I strongly object to the approval of SSD 7056. Please see my three original submissions regarding the issues it poses. The applicants' recent responses (May 2016) show that they have done little to address these and worse still, that at least some of their consultants, have not considered them worthy of a response. The submission which follows is my specific response to this amended SSD application.

The amended application retains the same misleading title, 'Remediation, Restoration and Adaptive Re-Use of Campbell's Stores'. It thus continues to hide the fact that a significant part of the proposal relates to a proposed new four-storey-high building in a space that earlier decision makers determined should be left vacant or, at the most, allow a sun protection

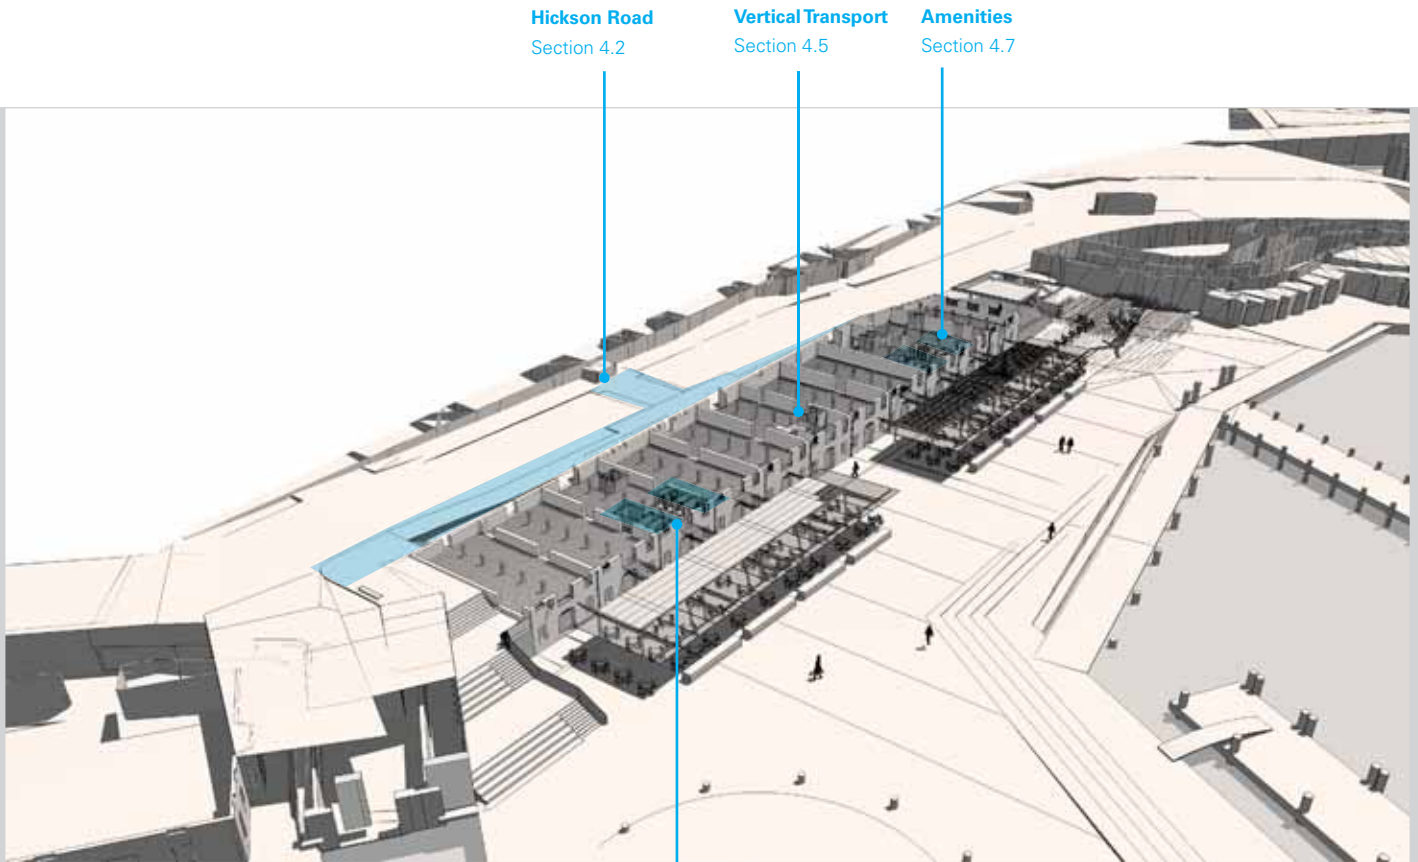
There has been no amendment to proposals to direct all kitchen exhaust through the roof of Bay 11. This is the location likely to have the greatest noise and fumes impact on occupants of both 8 Hickson Road and the Park Hyatt Hotel.

Applicants need to clarify the proposed stack height and provide images showing what it would look like. This, along with sound barriers erected to mitigate noise and fumes of the kitchen exhaust are likely to substantially impact on our Opera House views and the enjoyment of our home.

01 WEST ELEVATION  
SCALE 1:200

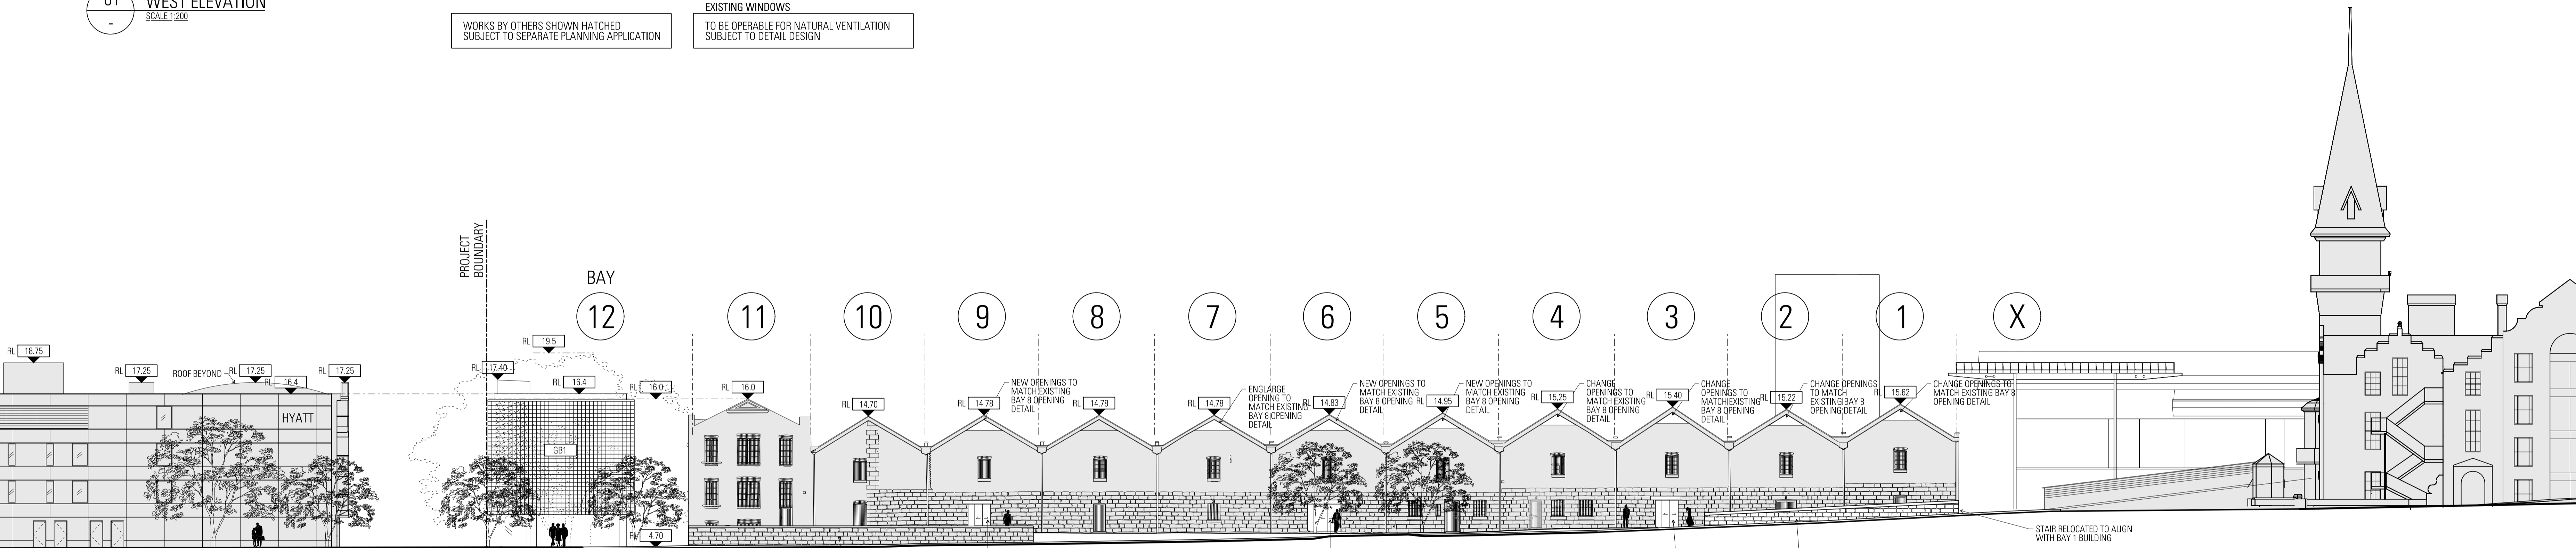
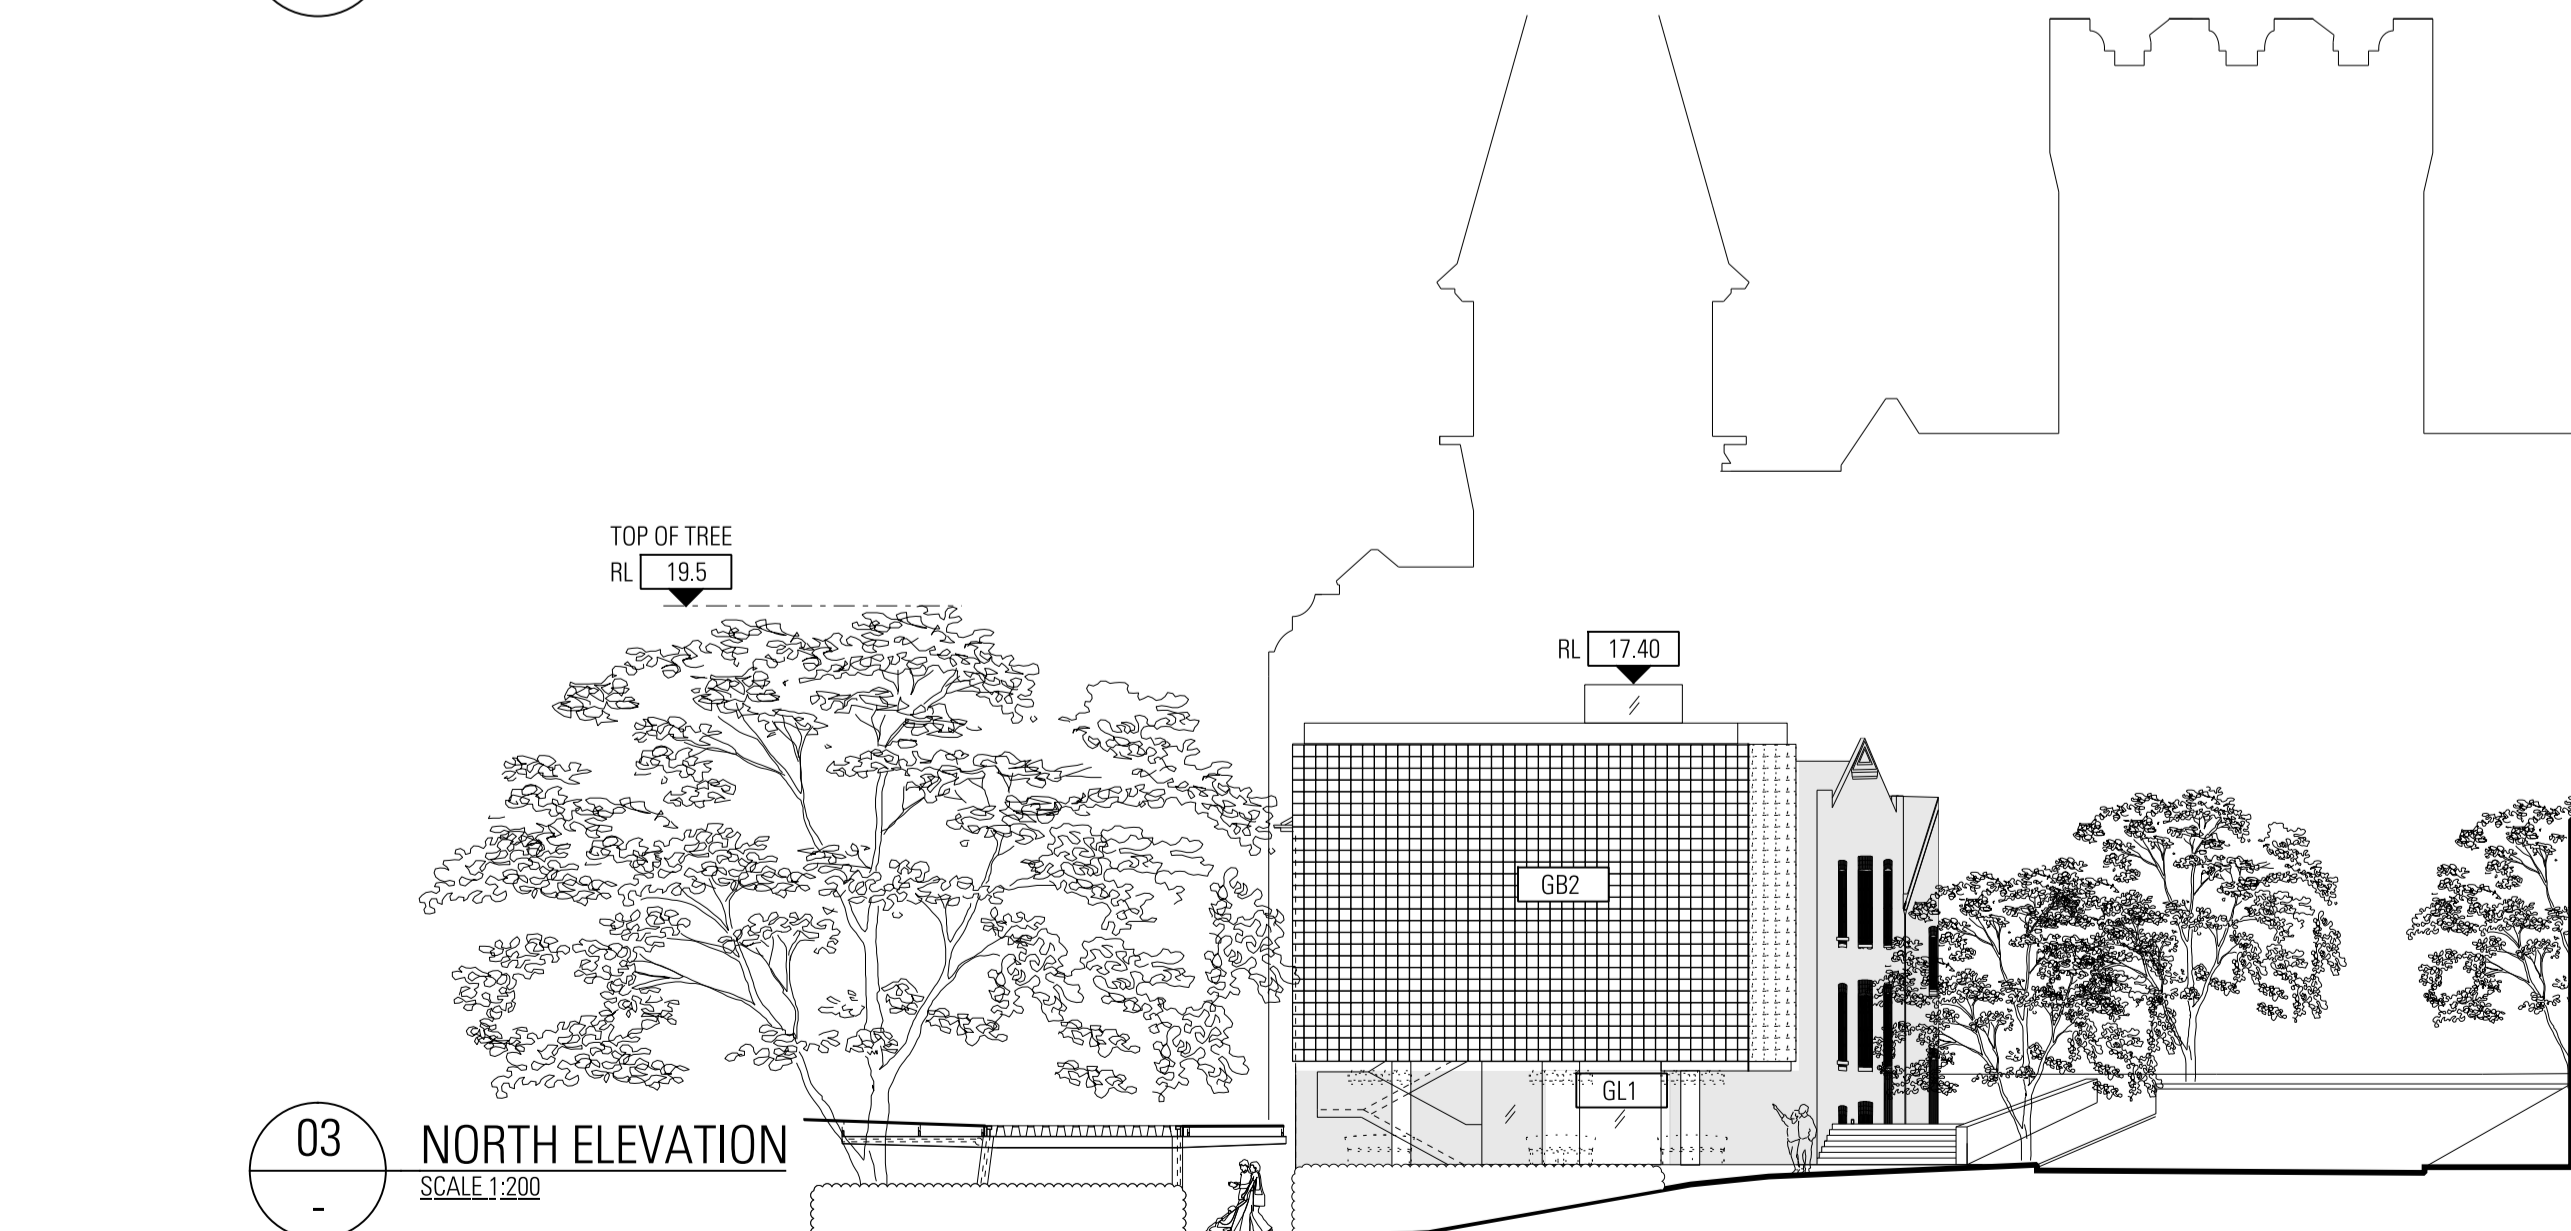
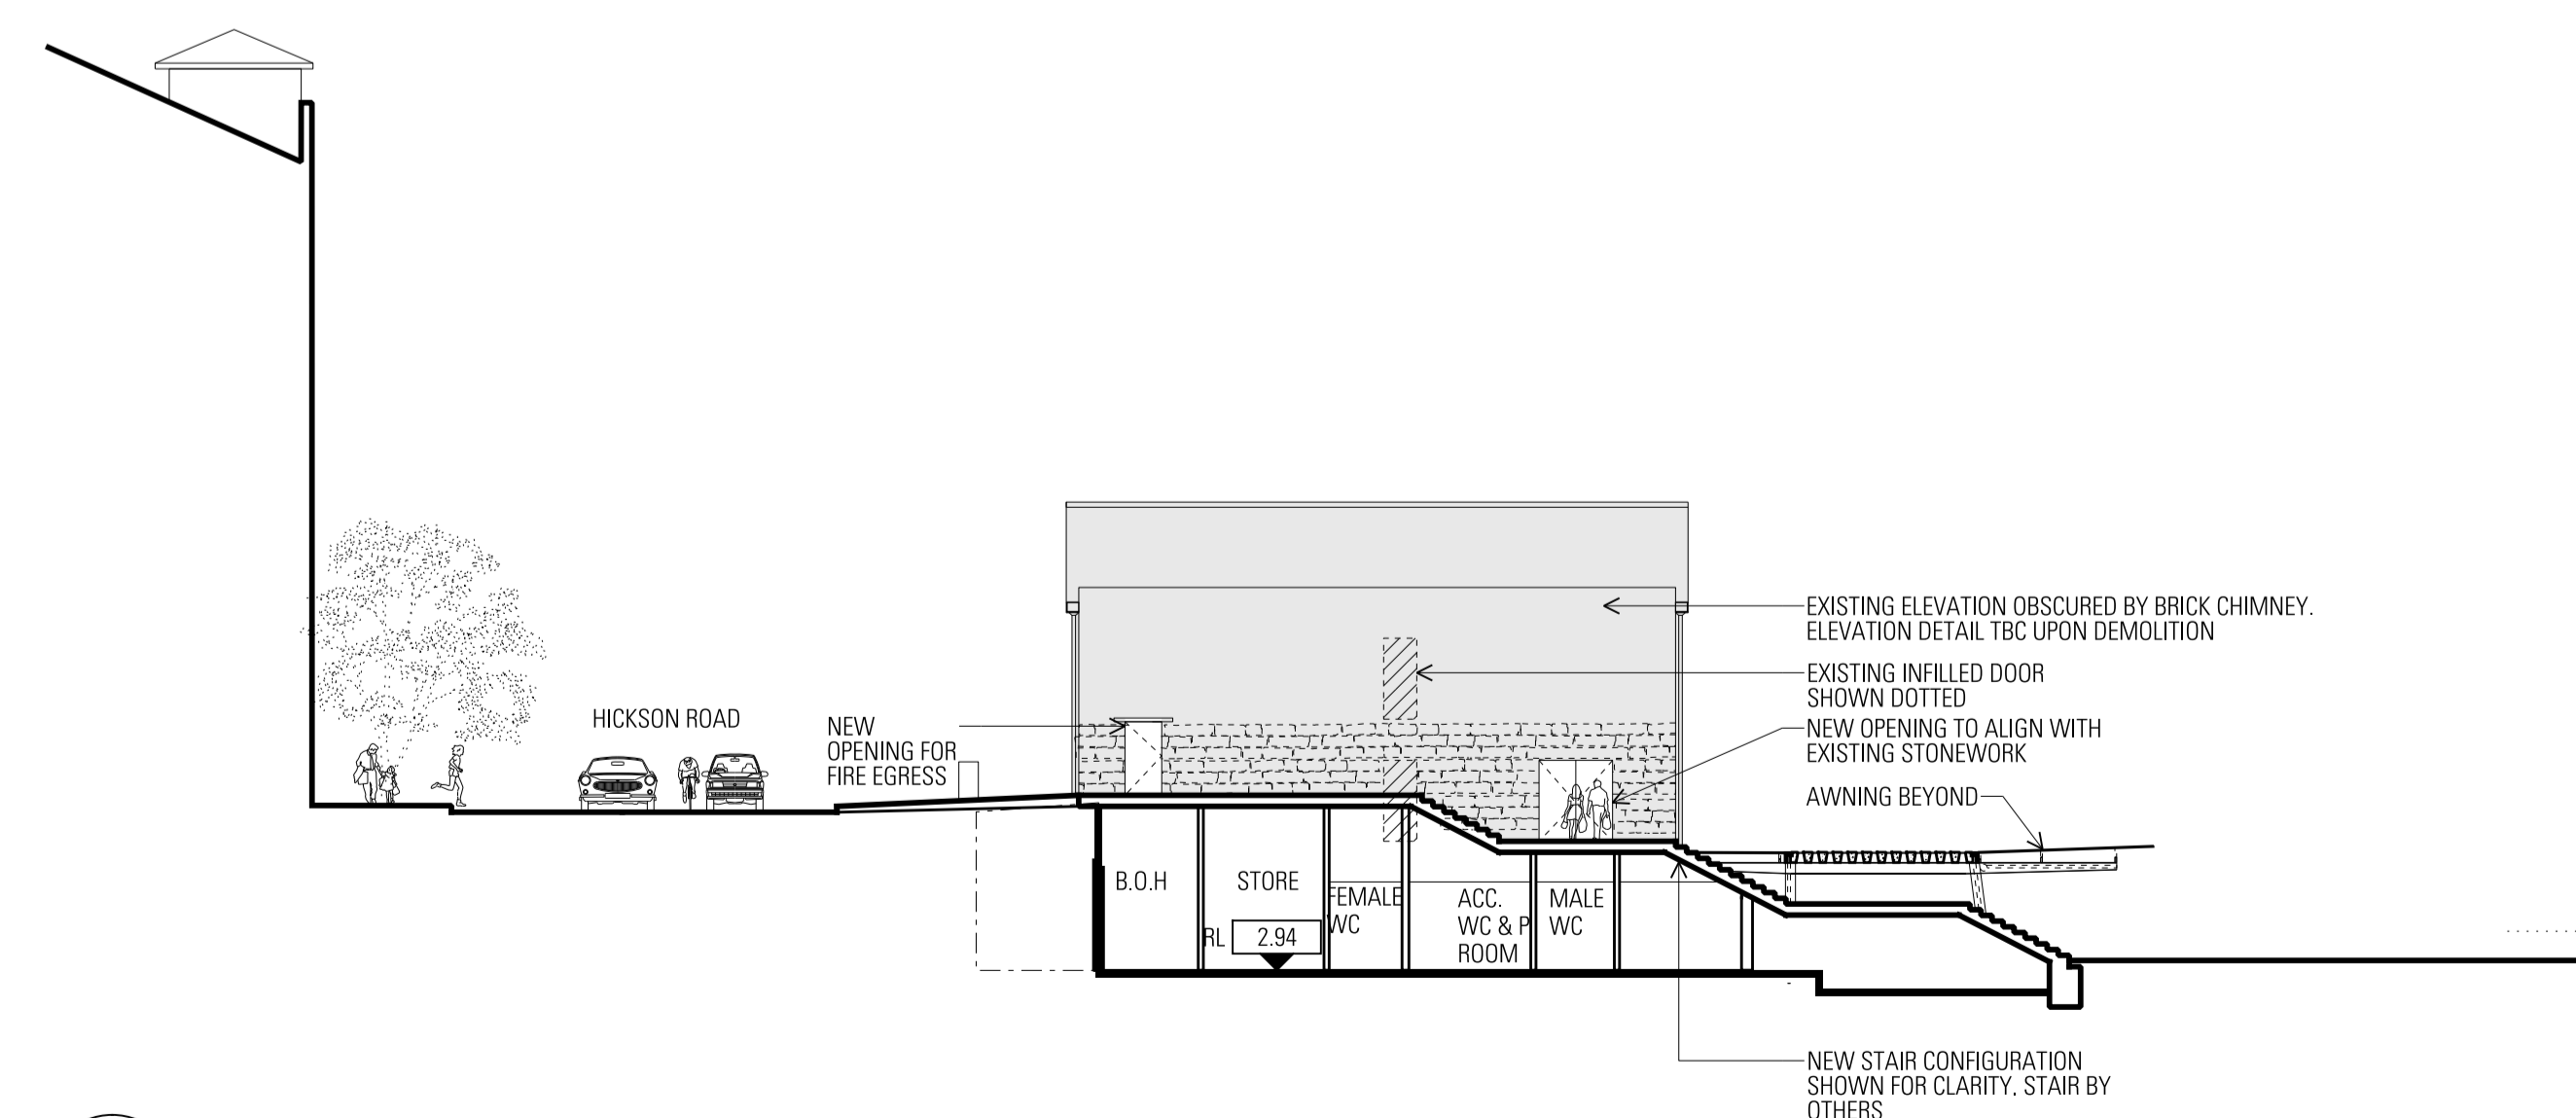
The proposed 'adaptive re-use' of Campbell's Stores, includes the intrusion of a new, unsympathetic building into the heritage streetscape, hiding the northern end of Campbell's Stores and impinging significantly on the Stores' western facade, the only original facade still visible. While it is appealing to have the tenant applicants provide essential maintenance work, the new building should not be seen as a 'reward' the consent authority has to provide. With rent returns and recent sales of public-owned housing in The Rocks, there are alternative sources of maintenance revenue.

The applicant provides no response to the problems posed by the ventilation design for Campbell's Stores, in particular the proposal that this largely be treated by leaving restaurant windows open. This design would necessitate restaurants windows facing Hickson Road being left open for much of the year and so generate a significant and negative noise impact on nearby residents and on locals and others who just want to enjoy a stroll along the harbour foreshore. We currently experience such noise levels only occasionally when restaurant patrons at Campbell's Stores leave open doors that front Hickson Road.

Views from adjacent Residences

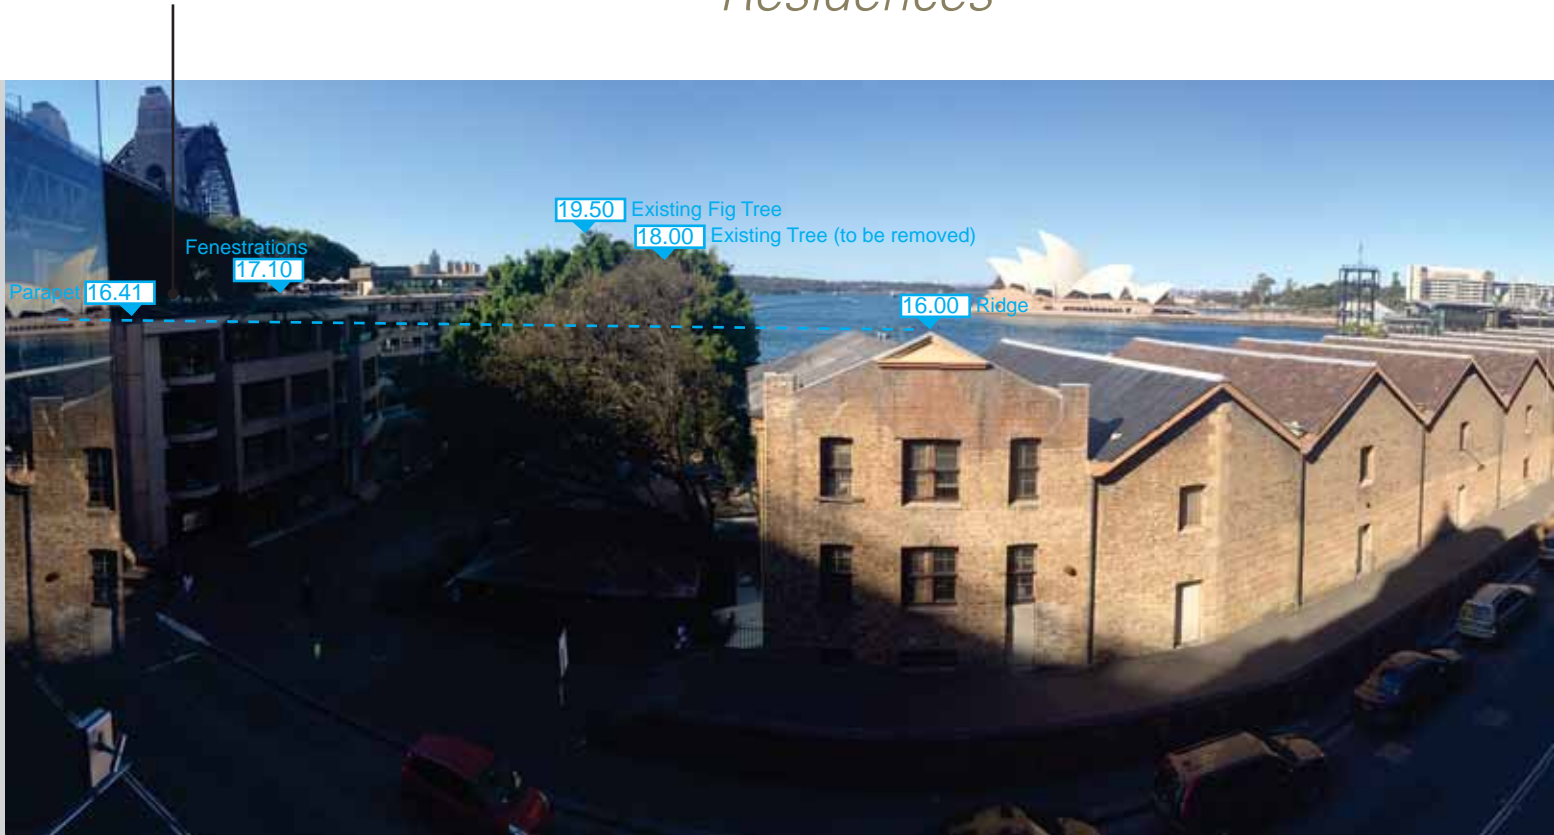
The drone images shown in Figure 13-16 are misleading as representations of views from specific individual apartments within 8 Hickson Road. The actual view is not as panoramic and some apartment views do not include either the Opera House or the Harbour Bridge.

The proponents seem to employ a limited concept of what constitutes a ‘view’, assuming that all views are at eye level. Some apartments at 8 Hickson Road have windows which direct people’s views upwards. For these, the new building might effectively block out both existing views and light. Apartments on the upper levels of 8 Hickson Road might find their views
